October 9, 2023

Re: Starbucks
Project #: PR-2023-008767
Application #: SI-2023-01512

Please find the following responses addressing comments received in a letter dated October 4, 2023. In an effort to address your comments concisely and simplify your review of these development plans, we have summarized your comments and our responses below. Your comment is listed first, followed by the response in Bold.

DATE: 24 May 2023
SCALE: AS NOTED
sheet: LS-101
of.

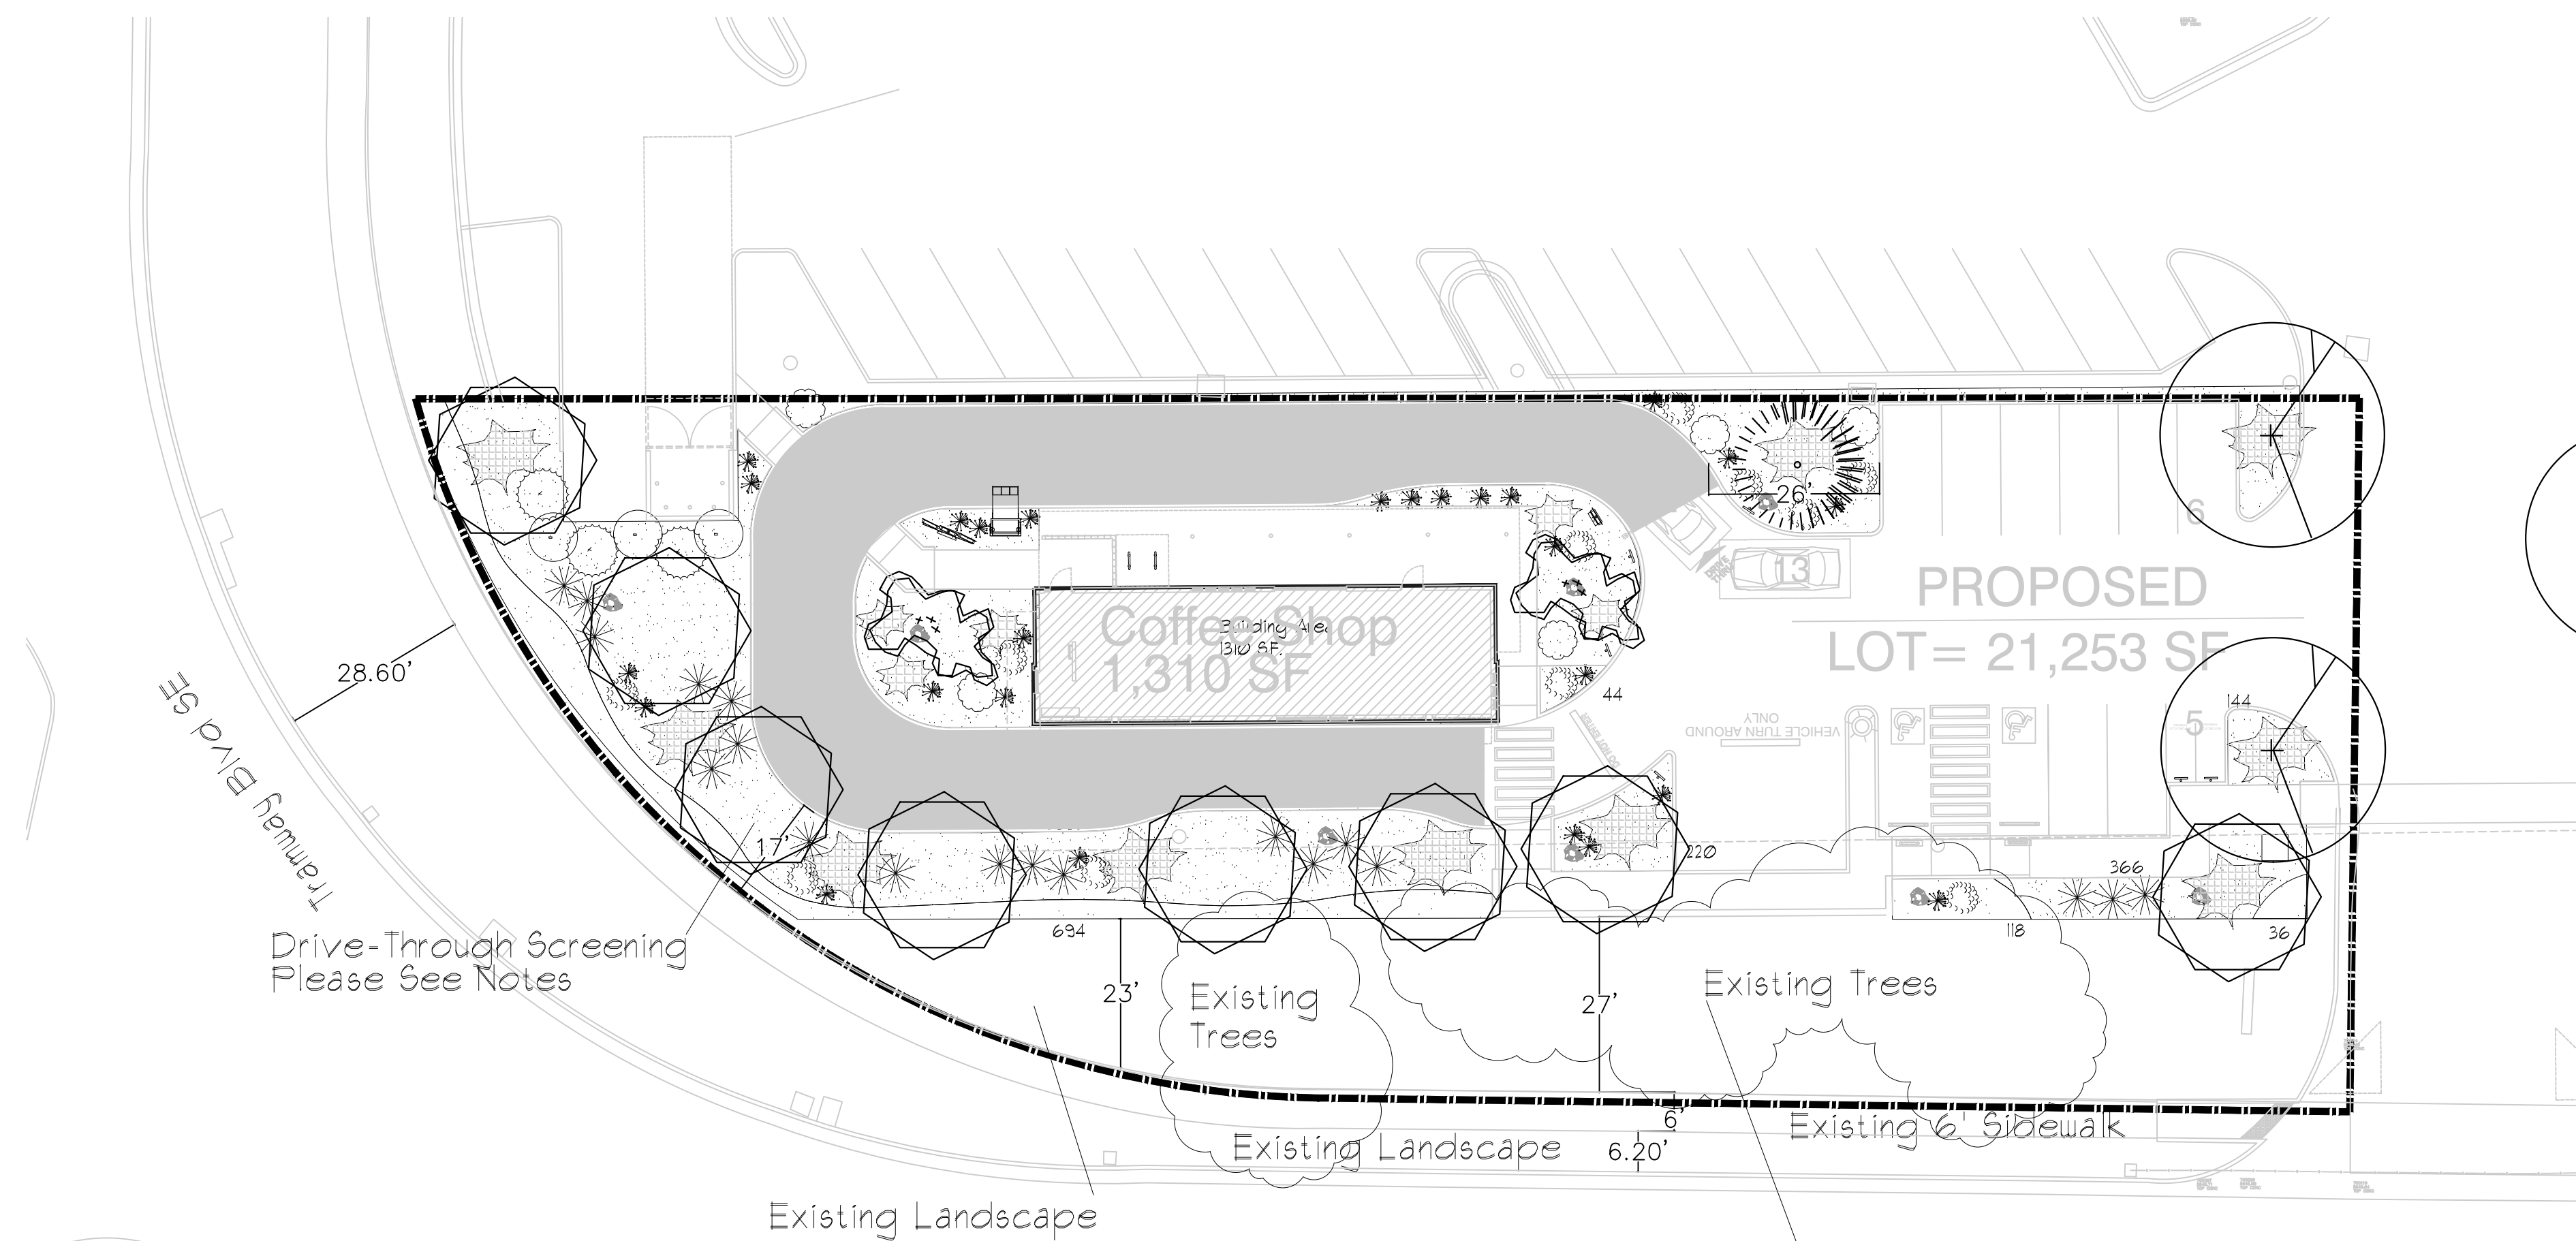
1. Existing Street Trees on Wenonah should be examined by the City Forester to determine if any replacements will be required per Street Frontage requirement in IDO 14-16-5-6(d). Please contact Sean O'Meil soneill@cabq.gov.

- The provided landscaping plan and calculations show that the development will be meeting the 15% coverage requirement. *However, please provide detail on how it is meeting the required standards and if/how the landscaping from the original approval/development will be affected.
Please include the street tree requirement, parking lot, street frontage requirement, and drive-through screening.

- Please clarify drainage pond landscaping.

Please identify/clarify ROW development/landscaping and the maintenance responsibility for any landscaping/buffering materials within an easement and/or ROW area.

Applicant Response: Coordination was completed with the contact above. Please see the attached email correspondence "KAFB Response". The comments made by Sean have been addressed on the Landscape Plan.

Applicant Response: The overall landscape plan from the original approval has been added to show the modified calculations. There is no deficiency being caused in the overall plan. The street tree requirement has been included in the Landscape Plan.

Applicant Response: Refer landscaping plans. Drainage pond landscaping has been provided. See landscape legend.

Applicant Response: The existing landscaping has been labeled on the Landscape Plan.

ENGINEER'S SEAL	STARBUCKS ON TRAMWAY ALBUQUERQUE, NM	DRAWN BY BF
	GRADING AND DRAINAGE BASIN MAP	DATE 09/06/2023
	TERRA WEST, LLC 5571 MIDWAY PARK PLACE NE ALBUQUERQUE, NM 87109 (505) 858-3100 www.tierrowestllc.com	2023047_BASINS
09/06/2023		SHEET # C1
RONALD R. BOHANNAN P.E. #7868		JOB # 2023047

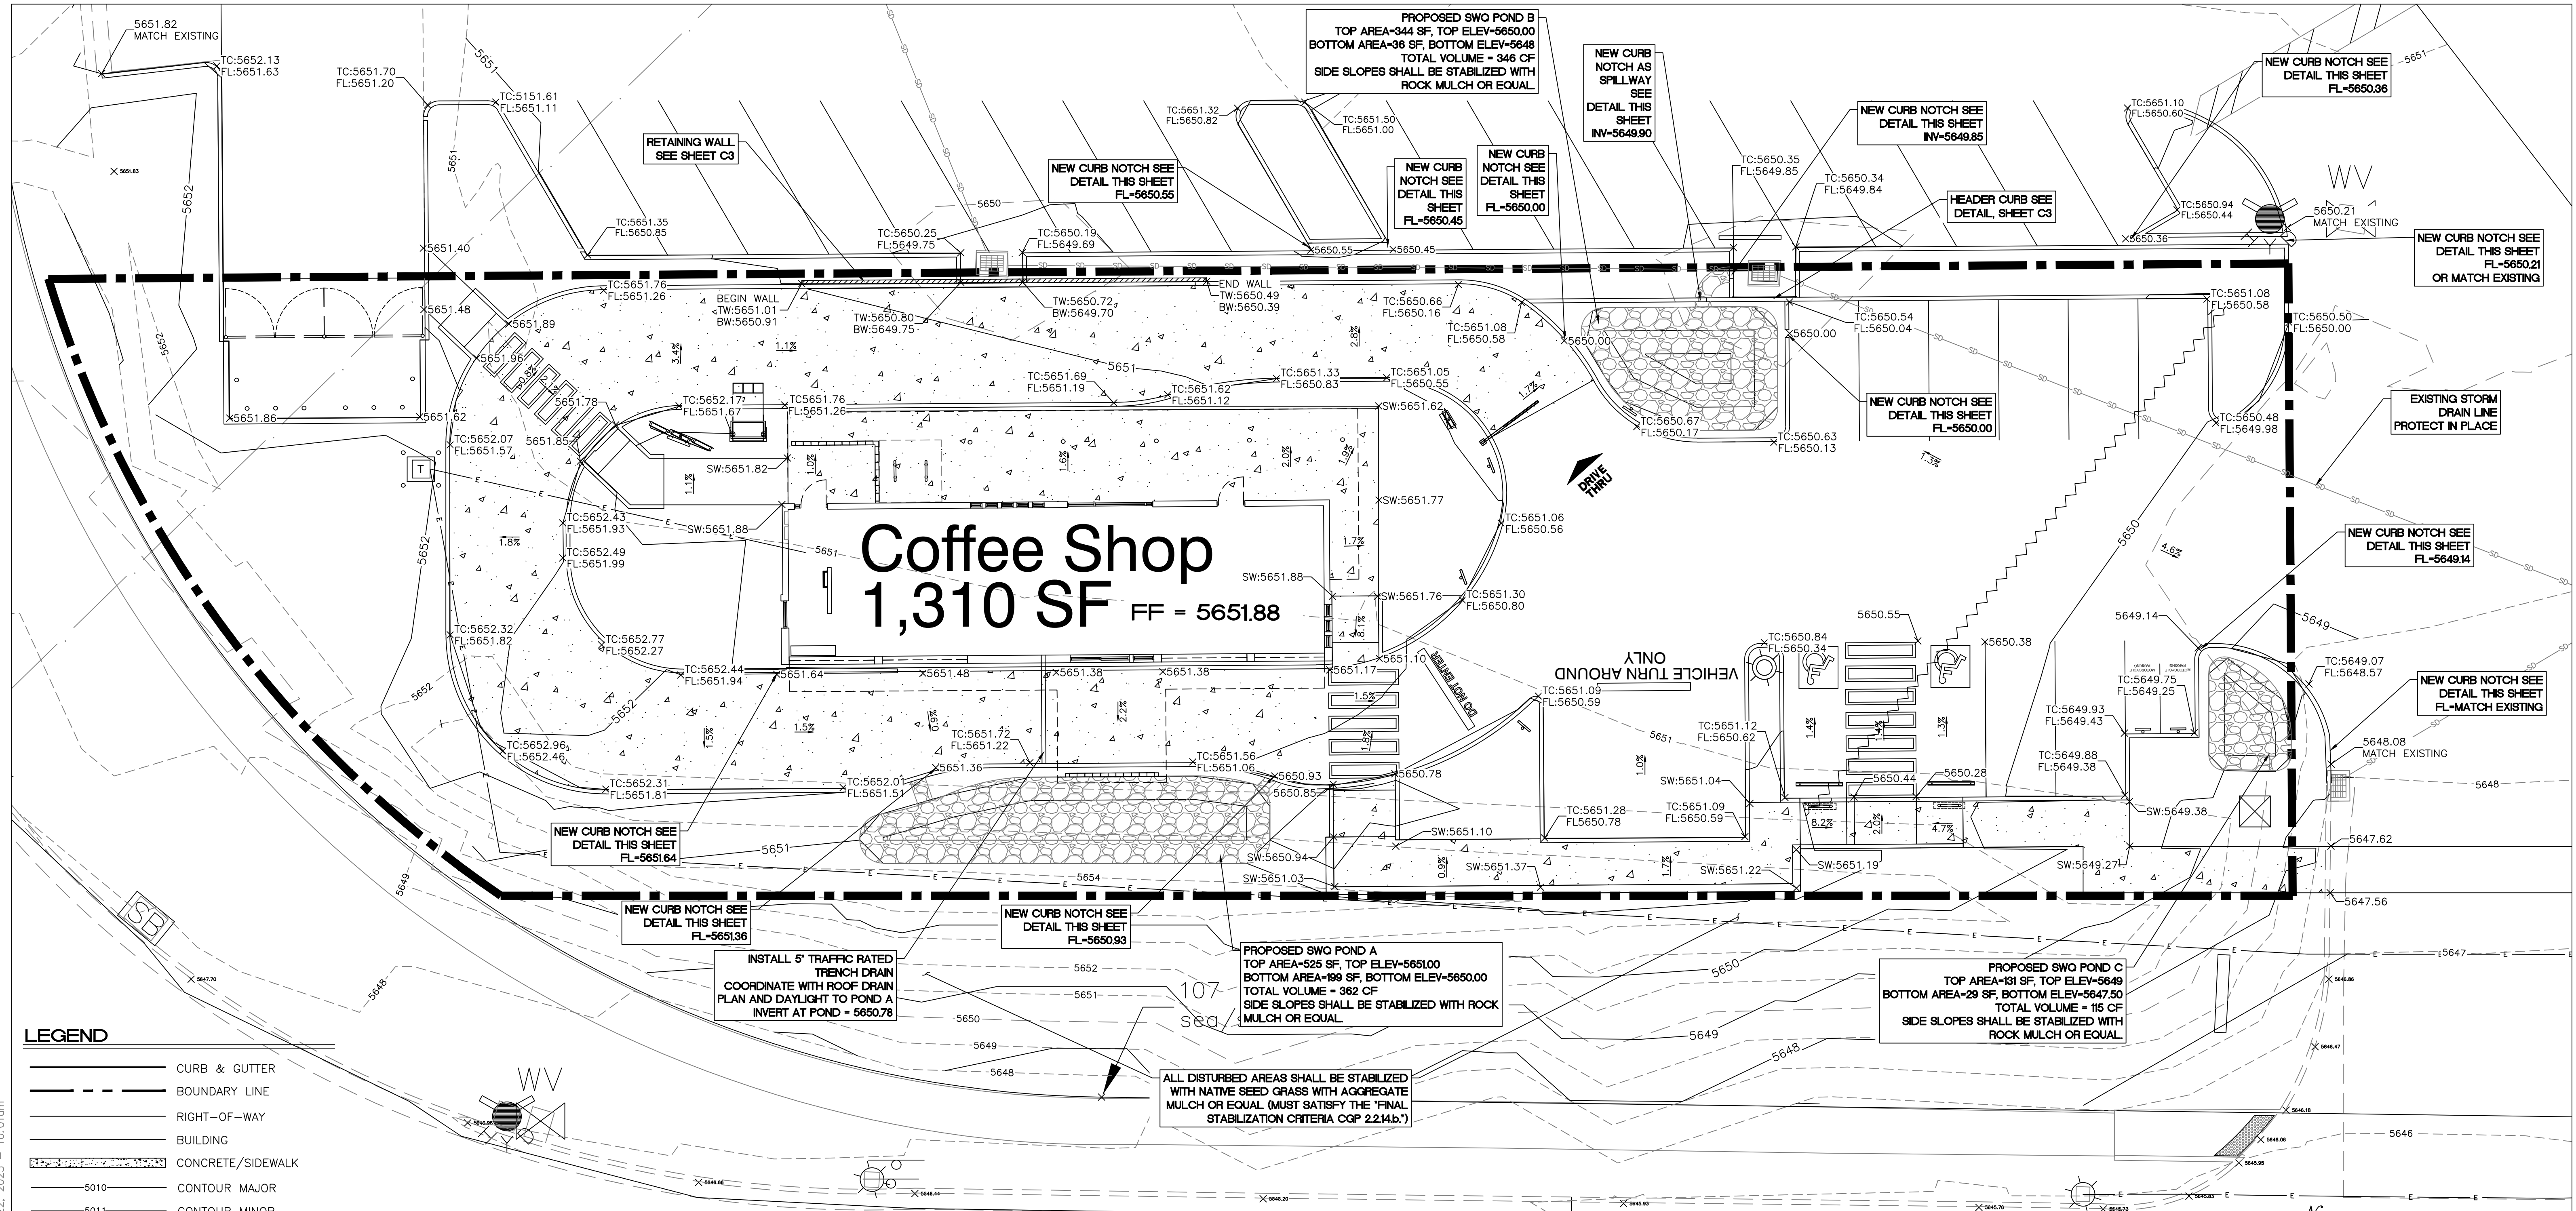
3. *Major Amendment: An amended Grading and Drainage Plan shall be provided prior to submitting the associated Site Plan to DFT.*
The applicant provided the amended Grading and Drainage plan. A note shall be added to sheet C1 stating that the EPC approved the requested amendments on 7-20-2023. The G&D Plans show existing and proposed G& D as sheet C3.

Applicant Response: Note added to sheet C1.

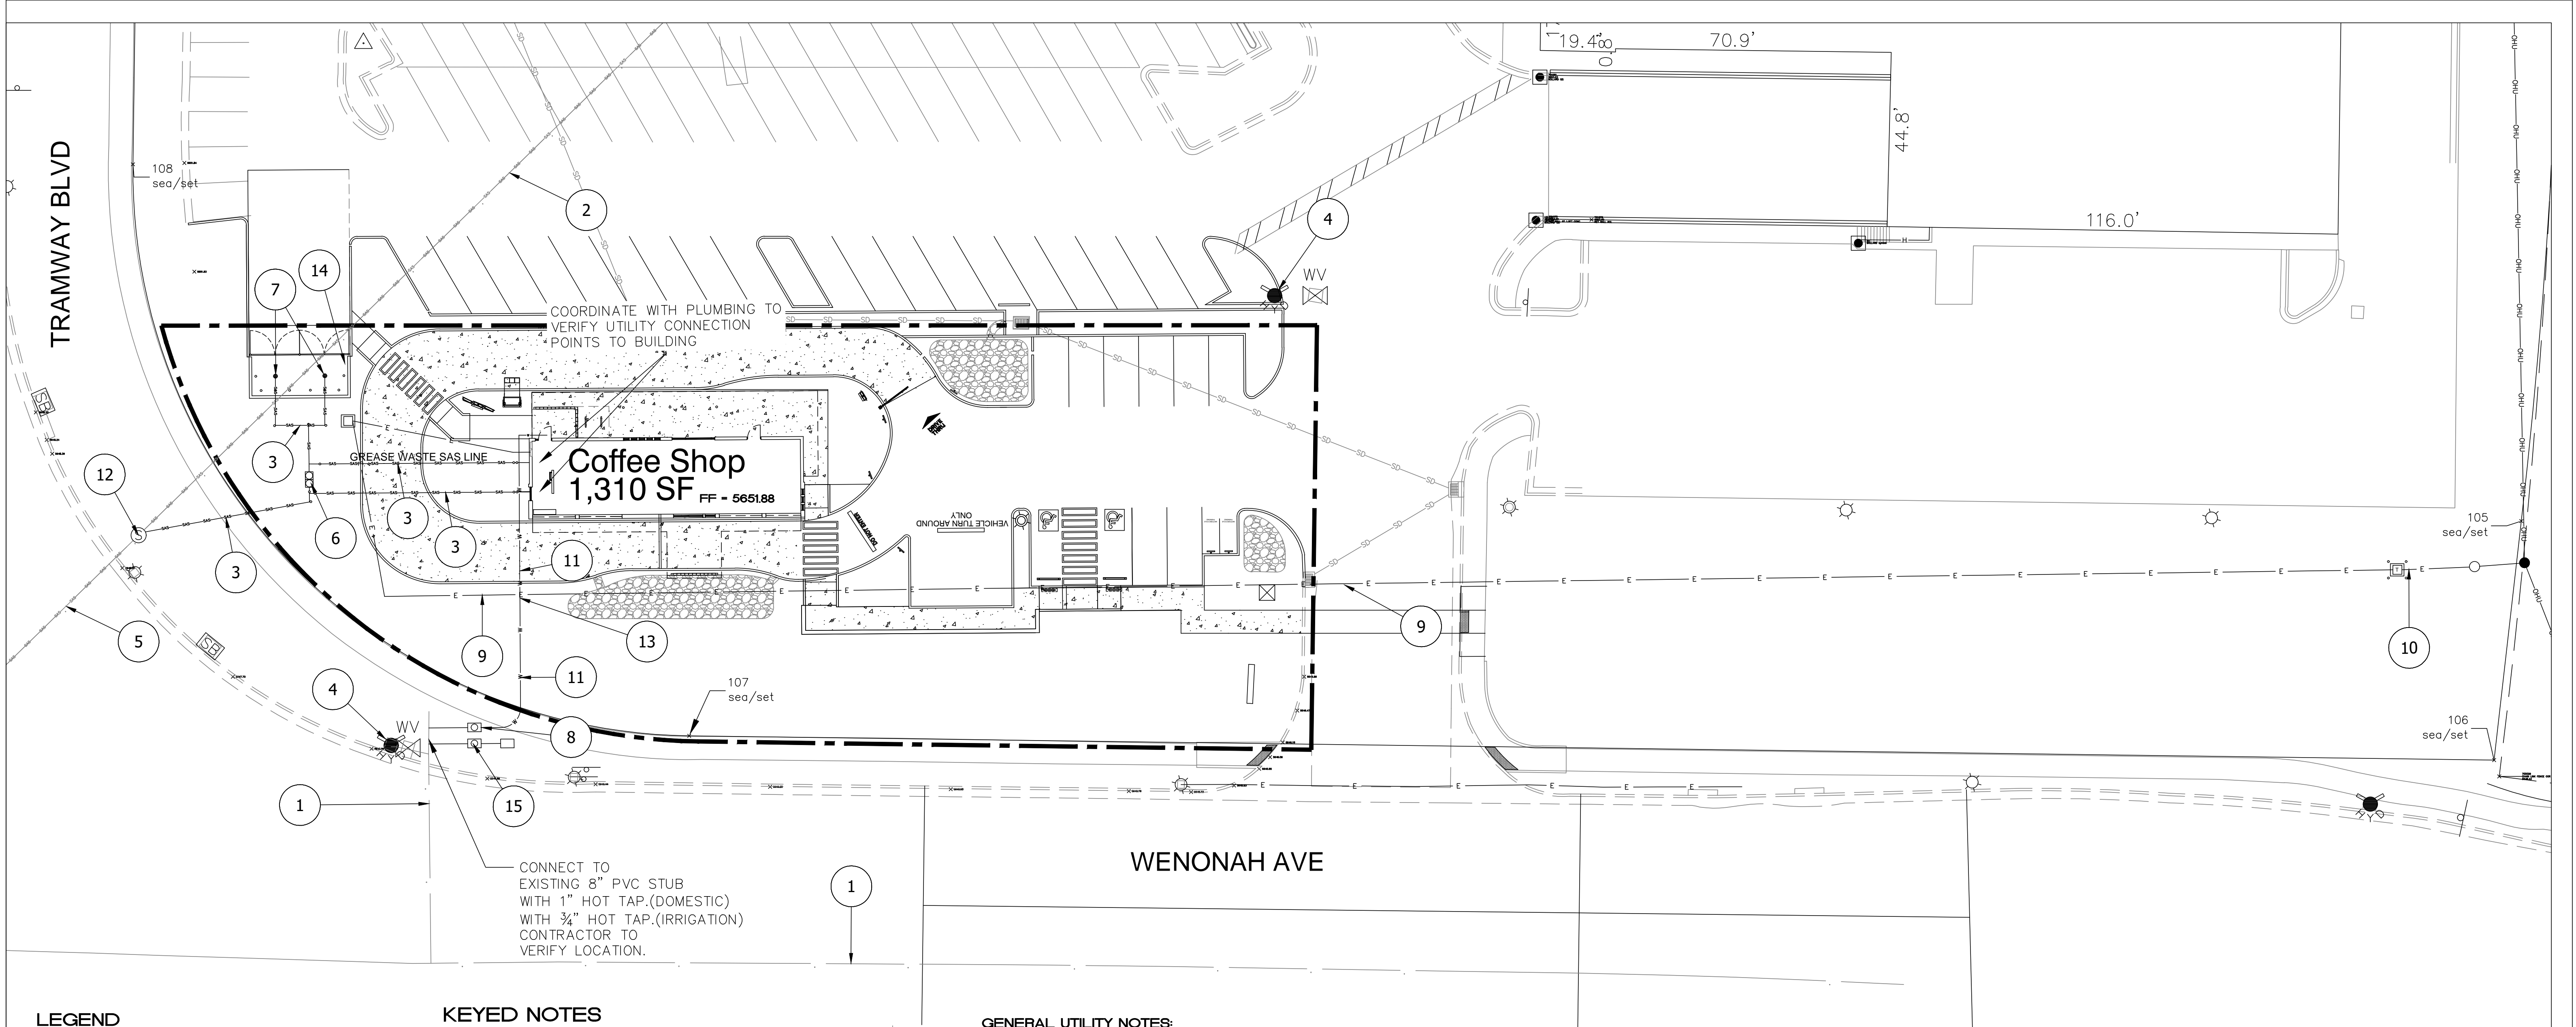
1. Utility Plan:
 - a. No objections.
 - b. Please add the following notes to the Master Utility Plan:
 - i. Coordination with Water Authority Cross Connection Section will be required to ensure proper backflow containment is in place prior to release of meter for the site. Contact the Cross Connection Section at 505-289-3454.
 - ii. Coordination with the Water Authority Pre-Treatment Engineer is required to ensure the site complies with Water Authority Sewer Use Ordinance. Contact the Pre- Treatment Engineer at 505-289-3439.

Applicant Response: ABCWUA notes added to master utility plan sheet C4.
